REPORT UPDATE

Application No: F/33/26/PL

Recommendation Report for Planning Permission

PROPOSAL: Replacement of existing cladding, installation of new roller shutter doors, roof alterations including increase in eaves height and alterations to fenestration. This application is in CIL Zone 2 (Zero Rated) as other development.

HANGAR 1, PROPOSED SOUTH ELEVATION (1:200)

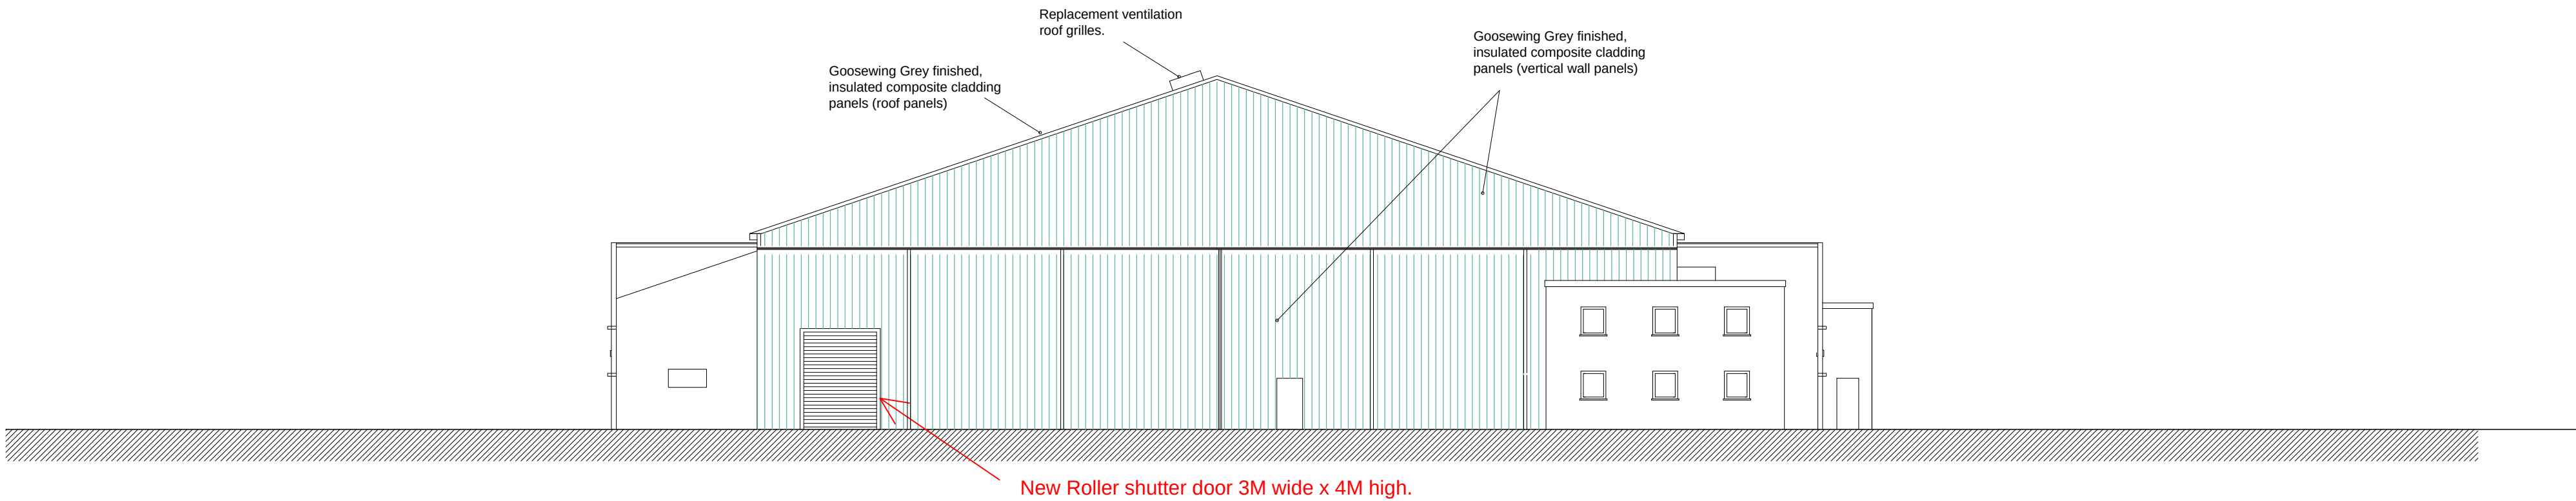
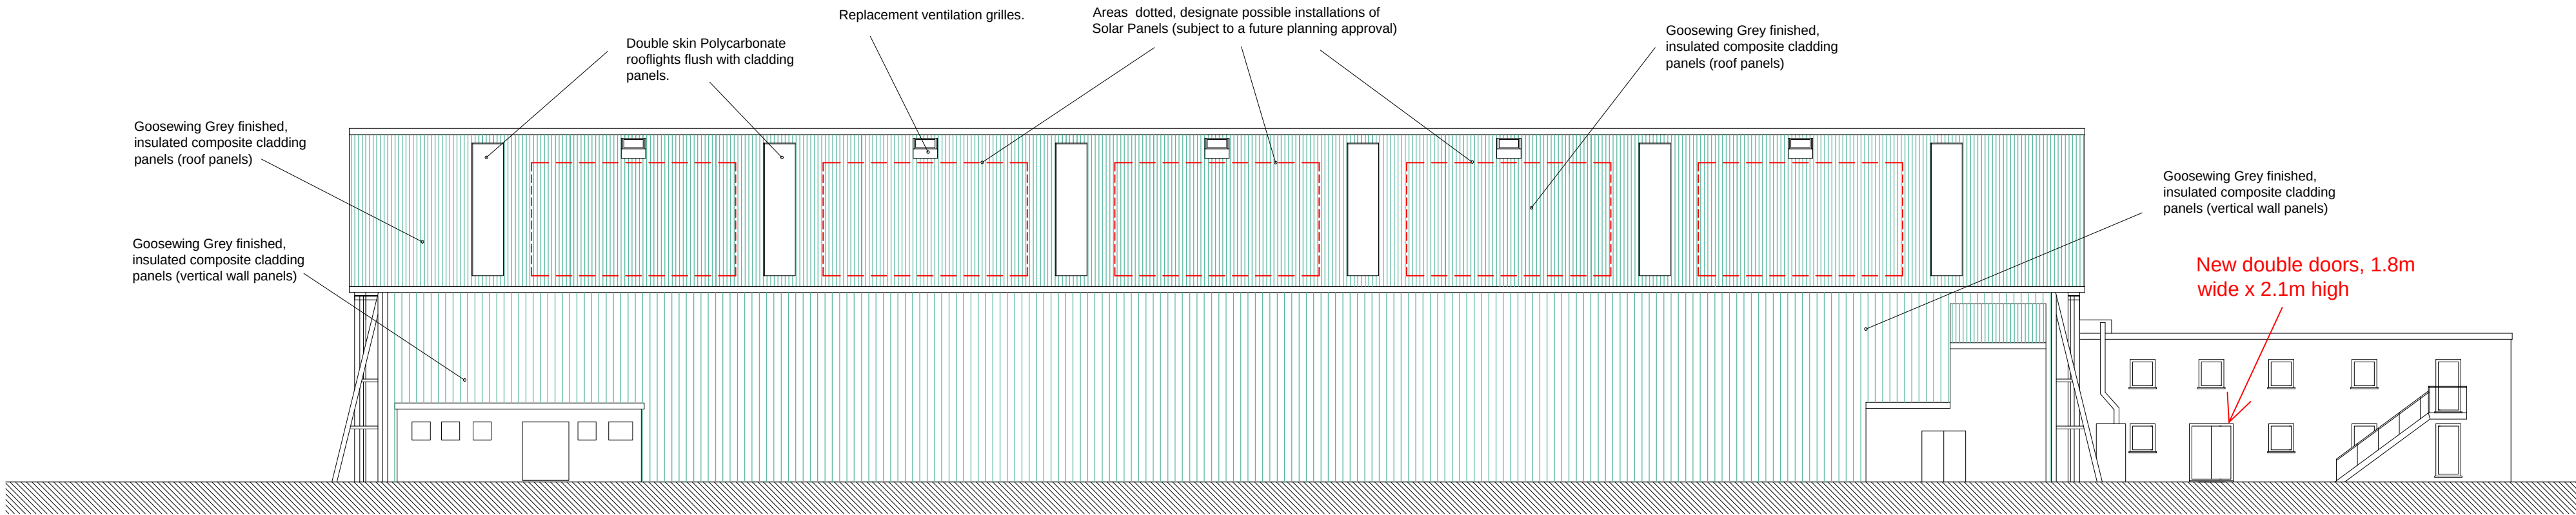
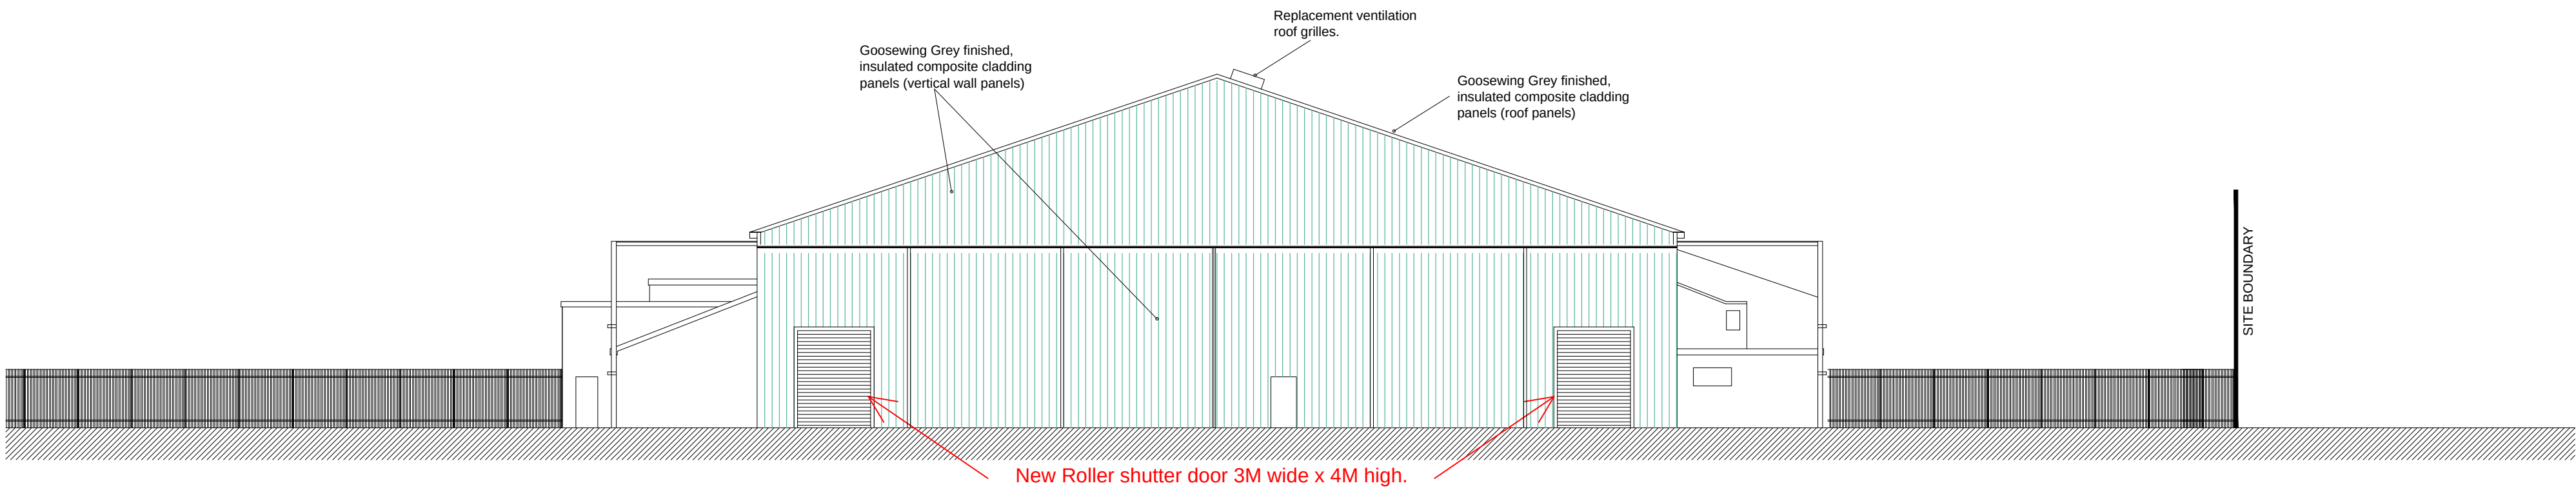
The existing eaves height is approx. 8m, which would be raised to a height of 12.2m. This would alter the appearance of the building, and would increase its bulk, although the overall height remains the same. The increase in eaves height reflects works to Hangar 2 to the east, approved under F/1/26/PL. The proposal do not result in an increase in height, and the building would not appear at odds with the surrounding landscape or buildings. Although representations have raised concerns about the impact of the building on the wider landscape, the change in eaves height would not make the building more visible in distant views to any significant degree.

Alterations to the roof include alterations to rooflights, which would be replaced with high level eaves lights at the top of the walls on the north and south elevations. Four large roller shutter doors with an approx. height of 7.5m are proposed on west and east elevations. The alterations to fenestration would result in an appearance which is typical of an industrial unit and would not detrimentally impact the appearance of the site or the wider area.
